Acceptance of Applications Checklist

Wheelabrator Kemsley (K3) Generating Station and Wheelabrator Kemsley North (WKN) Waste-To-Energy Facility

Section 55 Acceptance of Applications Checklist

Figure 2: K3 Works Plan

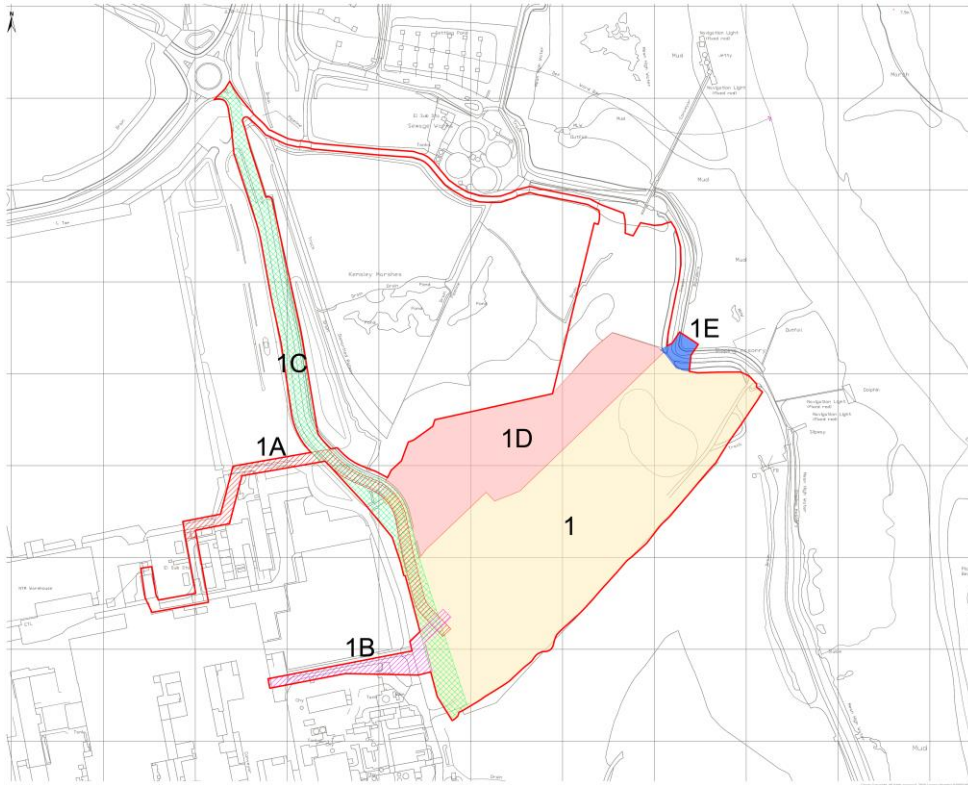
The Applicant has set out within their **Application Form** at **Box 12** those plans which qualify as the Works Plans. Schedule 3 of the draft DCO illustrates K3 Generating Station approved plans and documents, however it is unclear what the "K3 Approved Plan set" is, as the list detailed within Schedule 3 references numerous documents and plans, which include the 'Proposed Level Site Plan', which PINS is of the view is not a Works Plan.

Furthermore, **K3 Works Plan (Doc 5.5a)** refers to Works 1C and 1E, whilst **WKN Works Plans (Doc 5.5b)** refers to Works 4 and 7, these particular Works appear to reflect the same Works and therefore the Planning Inspectorate is of the view that these Works should be reflected as a single Works rather than duplications.
